Pls can the below comments be added to the case file online as 'Drainage Engineer further comments on construction detail drawings'

Comments on construction drawings;

BE/17/20/DOC – Condition 3 (Surface Water Drainage) and Condition 10 (Facilities to enable Car Charging of Electric Cars)

TITLE:
ON SITE HIGHWAY WORKS
TRAPPED ROAD GULLY POT DETAIL

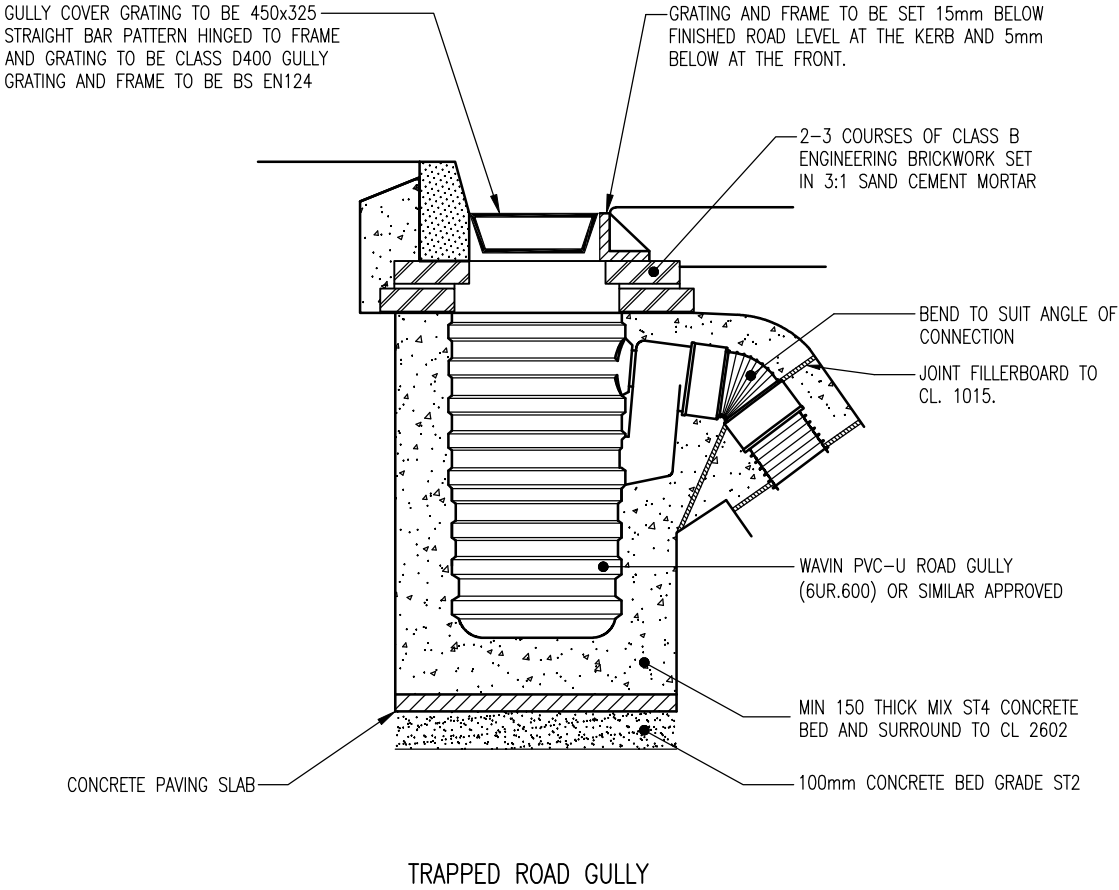
- 1. Yard gully – specify cover and frame grading.
- 2. Provide channel drain construction detail (including sump outlet).
